Hunsinger Subdivision

Letter of Intent

June 2018

FINAL PLAT HUNSINGER SUBDIVISION

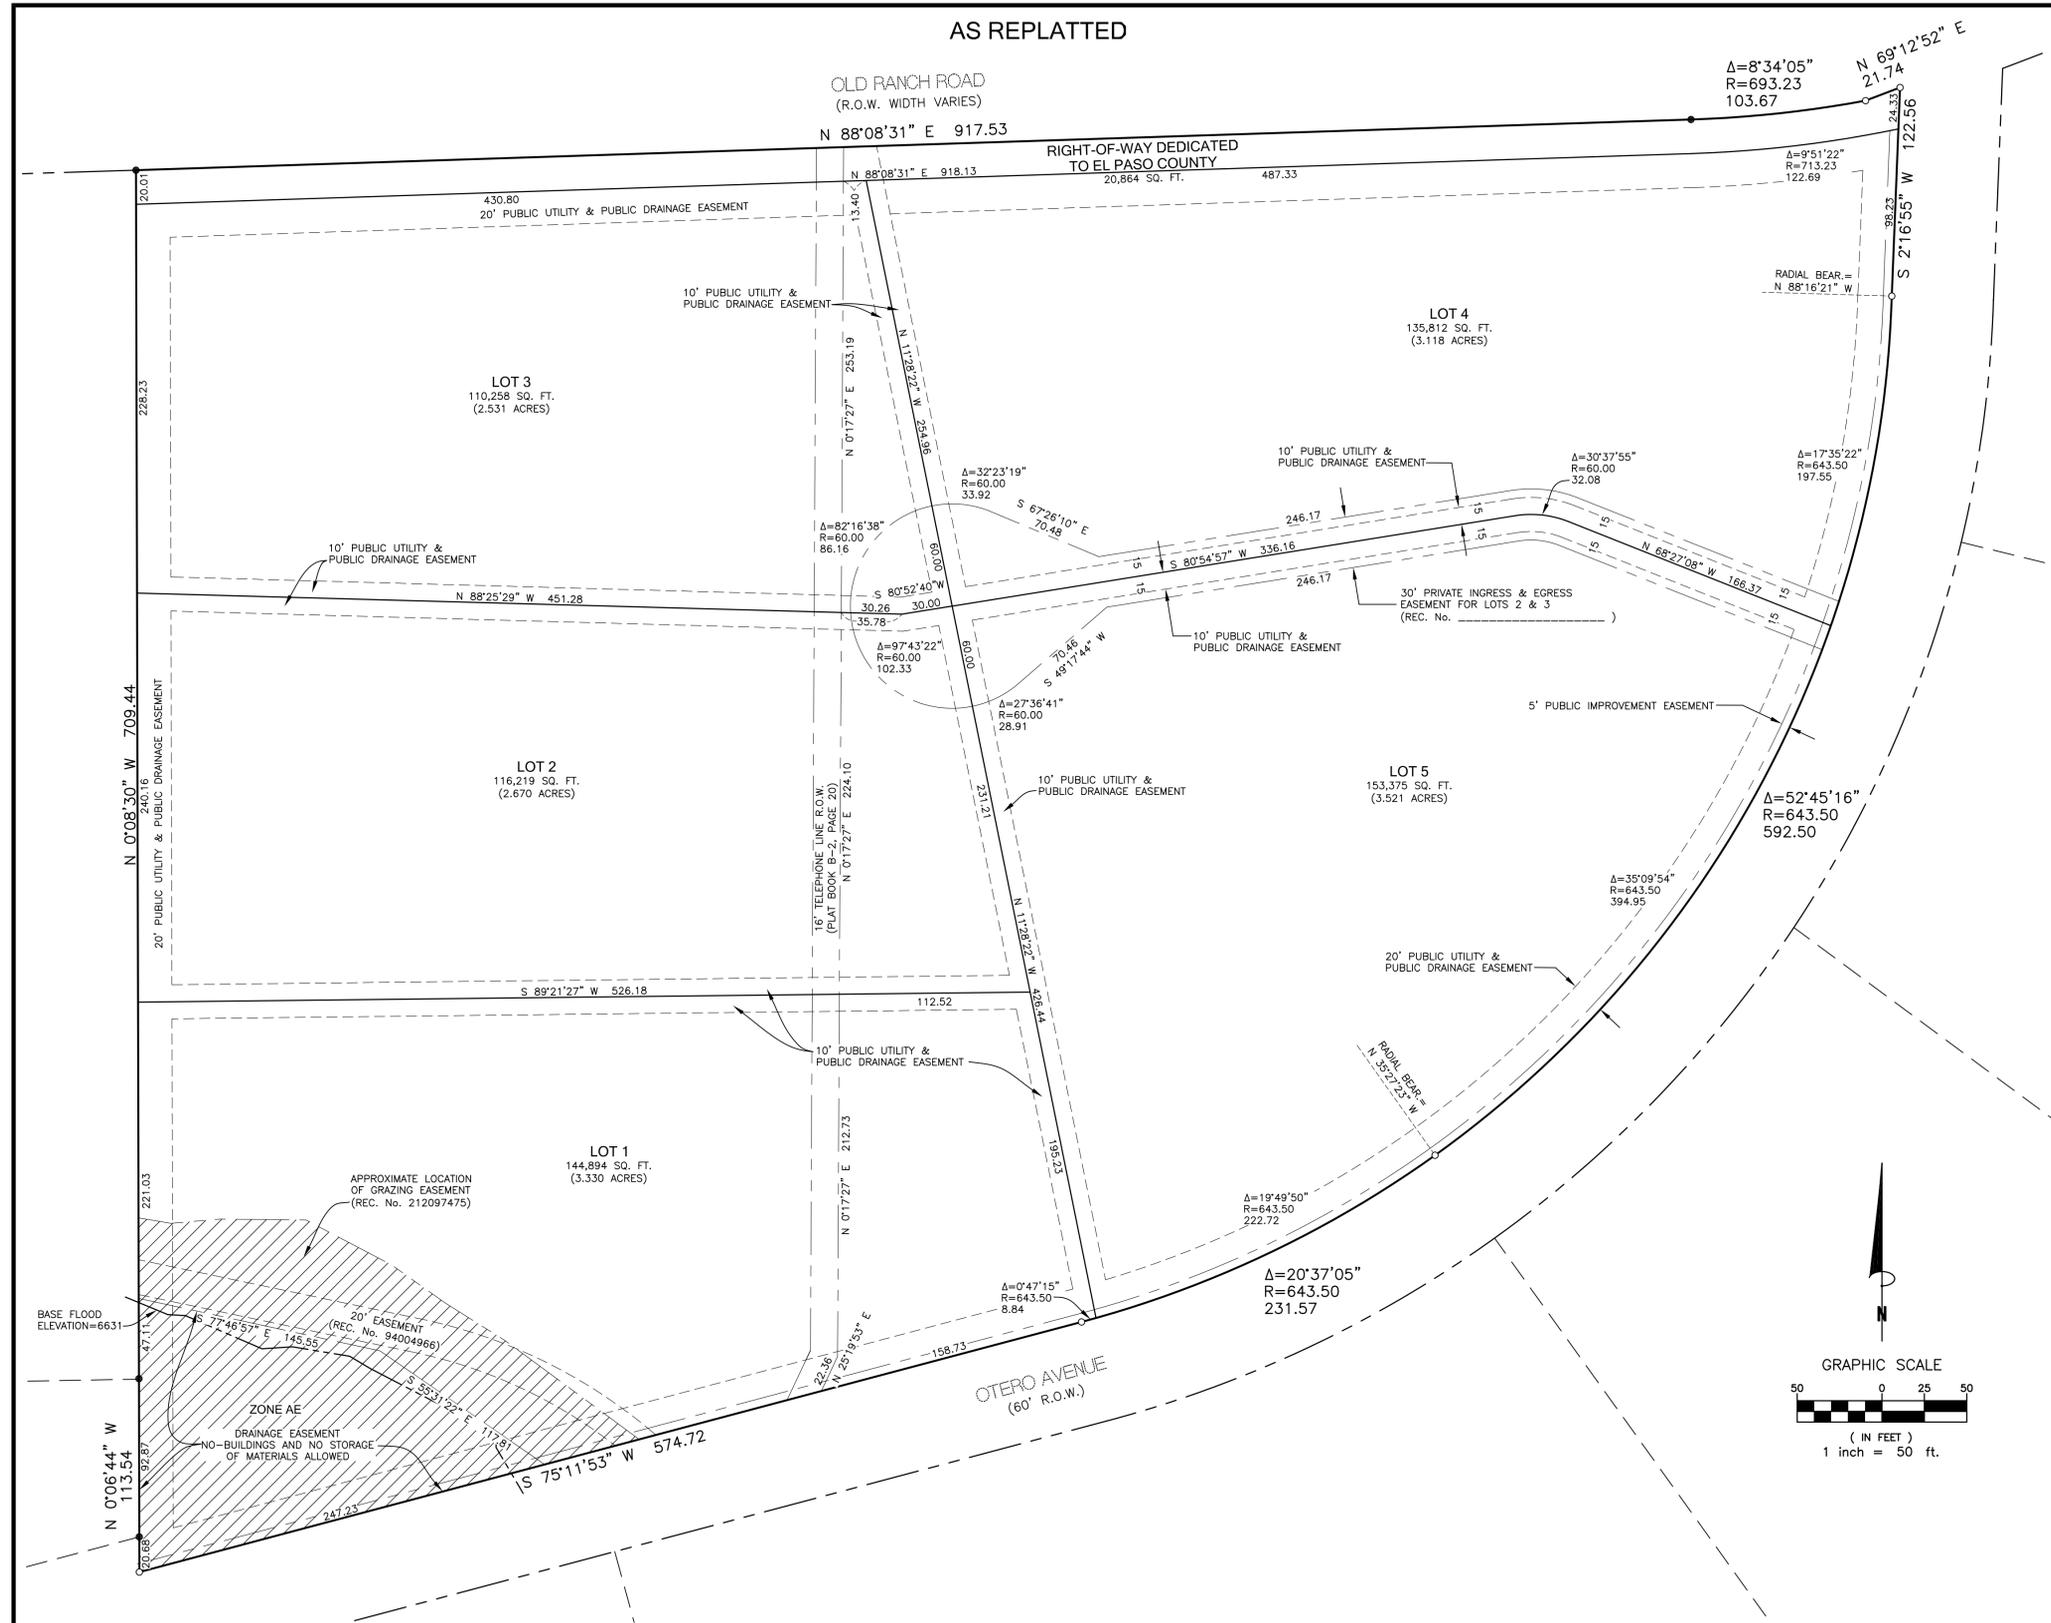
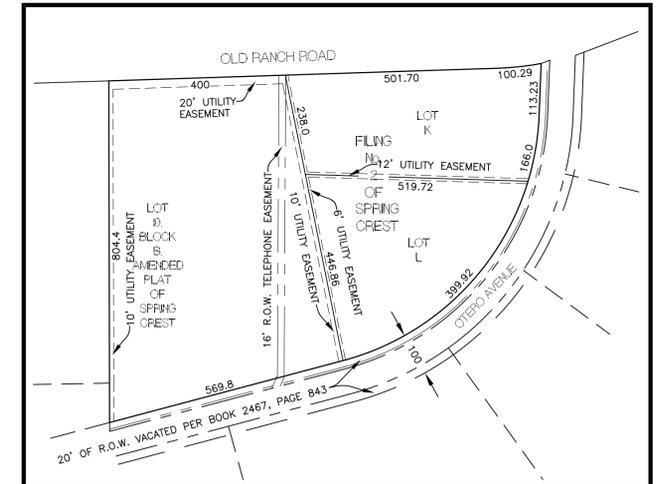
There should also be a waiver request for frontage of one of the lots, please refer to LDC 8.4.3

You are within 400 feet of a Municipal Sewer line, per previous discussion and the LDC a waiver of this requirement is required. The municipal authority must agree in writing that they do not require a connection due to some limiting feature. There are conflicting letters from CSU, one says you are within the electric area and are able to hook up, the other says you are not.
